CITY OF ALBUQUERQUE

June 22, 2016

**Re: HLP Endodontics
10429 Lagrima Del Oro NE
Requested for Permanent C. O. – Accepted
Engineers Stamp Date 6/29/15 (F21D063)
Certification dated: 6-2-16**

**FIRST FLUSH REQUIREMENTS**  
15100 x .34 / 12 = 427.83 CF  
PROVIDED 515 CF

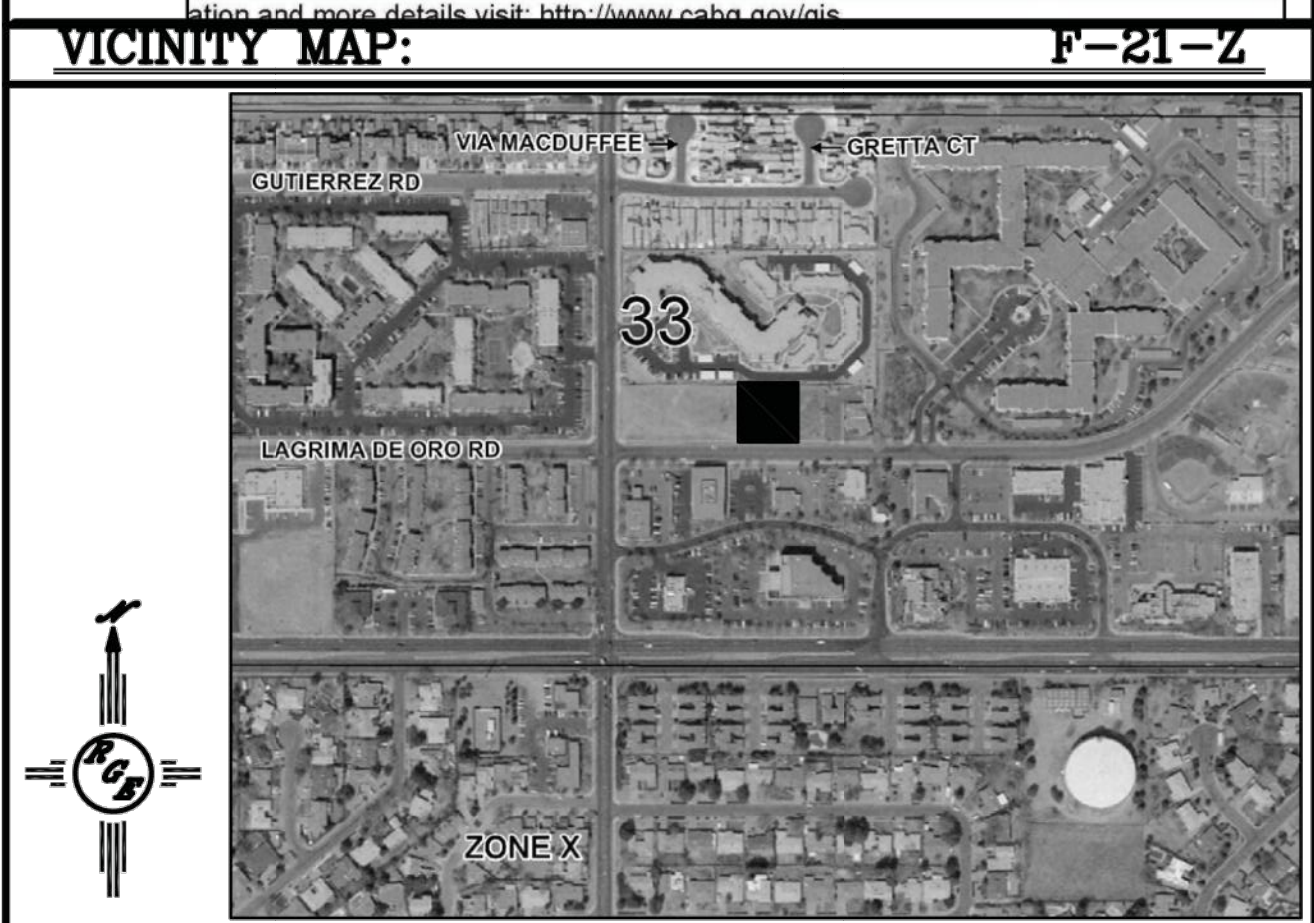
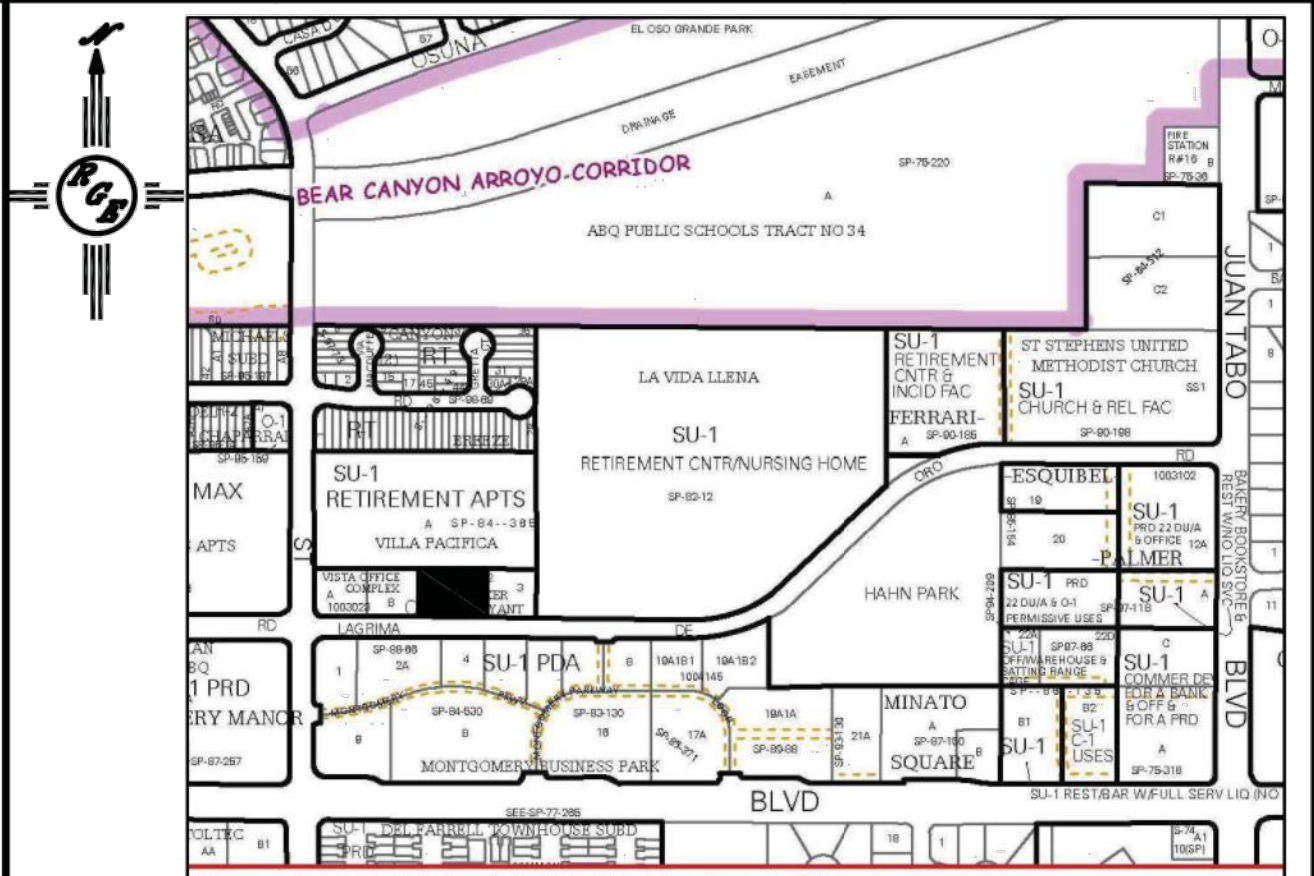
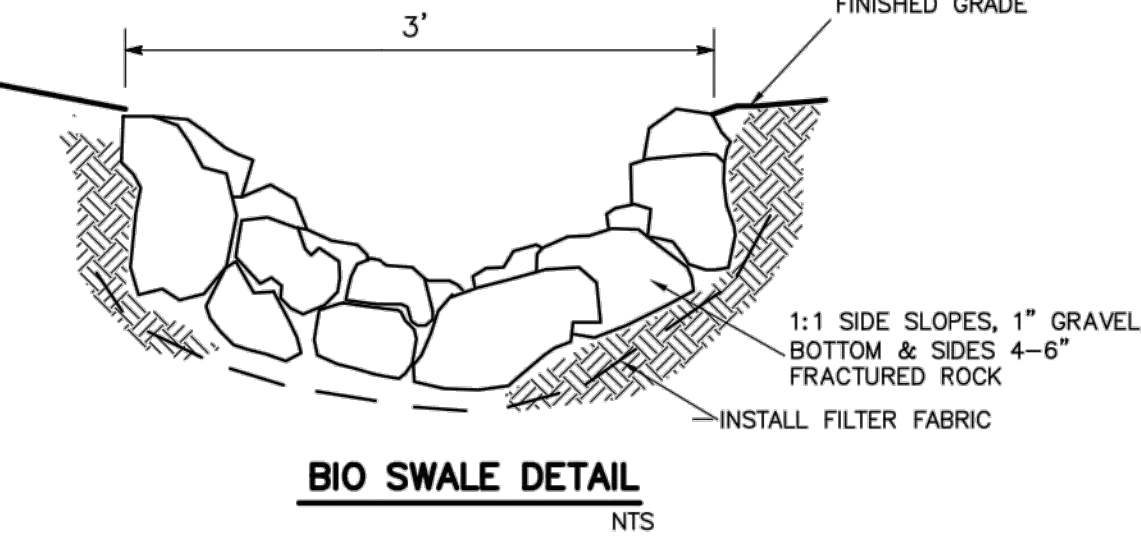
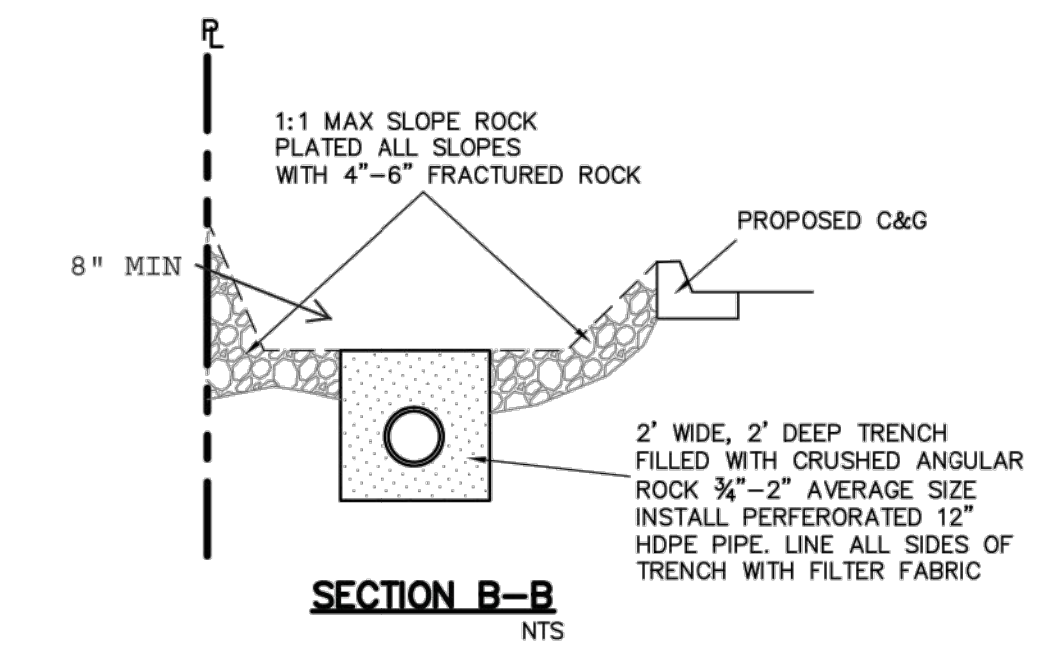
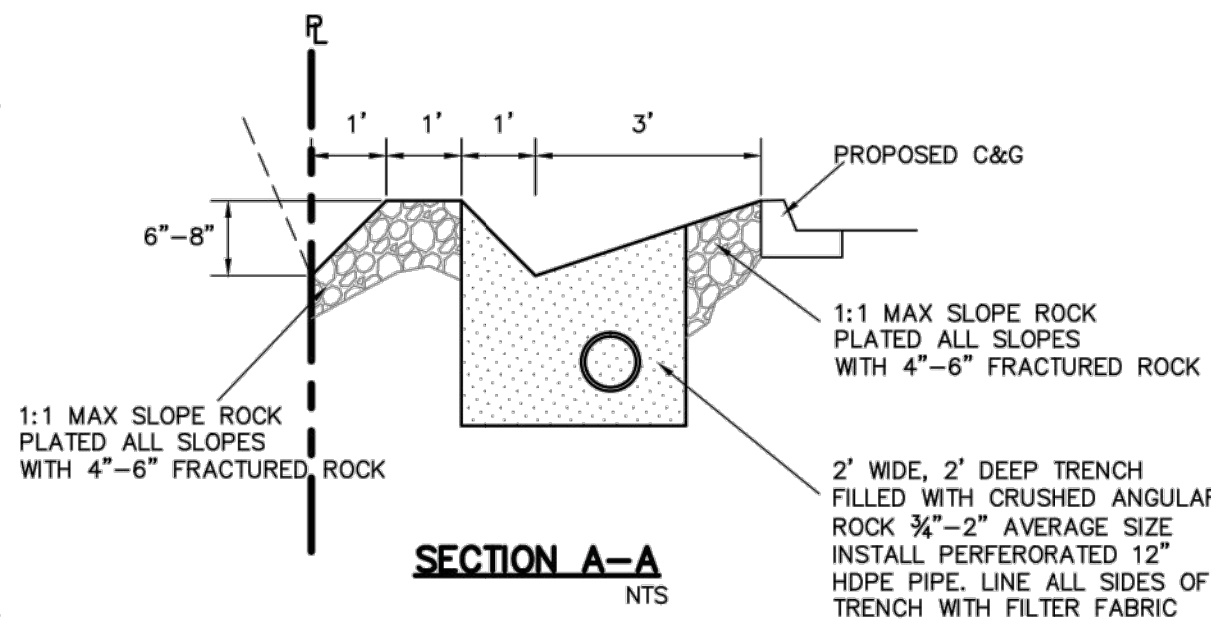
- Ensure that the transformer placed in the middle of the pond does not flood during a rain event. Contact PNM if necessary for recommendations.
